East Anglia ONE North and East Anglia TWO Offshore Windfarms

Draft Statement of Common Ground Substation Action Save East Suffolk

Applicants: East Anglia ONE North Limited and East Anglia TWO Limited
Document Reference: ExA.SoCG-38.D4.V1
SPR Reference: EA1N_EA2-DWF-ENV-REP-IBR-00109

Date: 13th January 2021
Revision: Version 01
Author: Royal HaskoningDHV

Plate A25.5.2 Predicted Noise Levels East Anglia ONE North

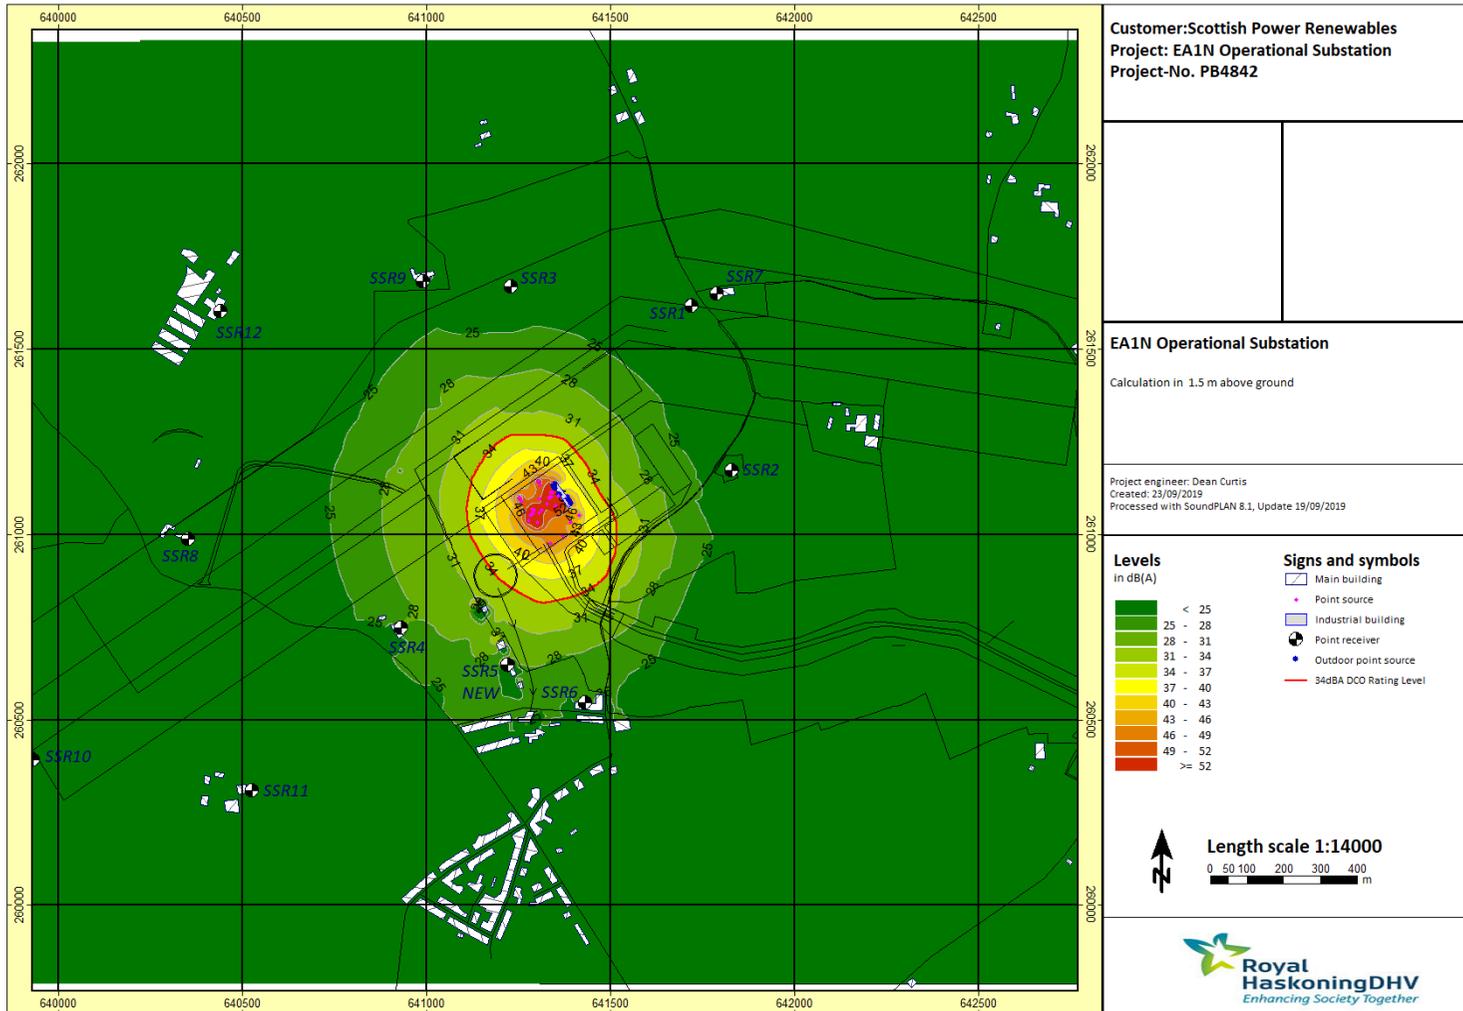
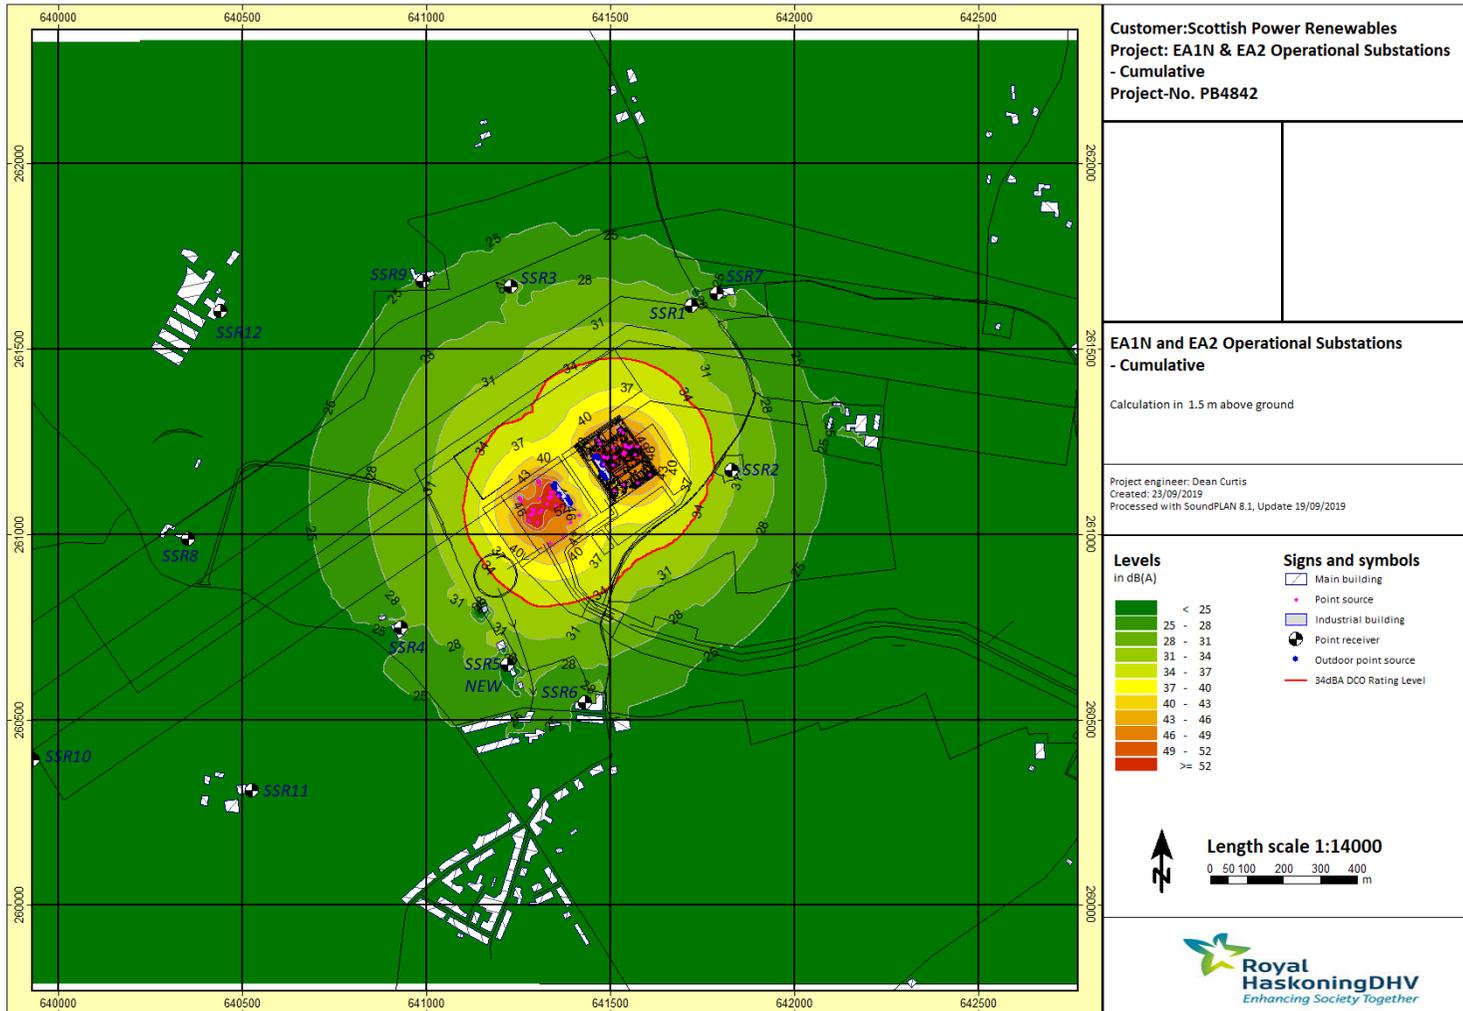
SASES-703	Assessment Methodology	The worst case scenario presented in	Agreed	Agreed	Not Agreed	<p><u>SASES Comments</u></p> <p>The scenario presented is not worst case.</p>
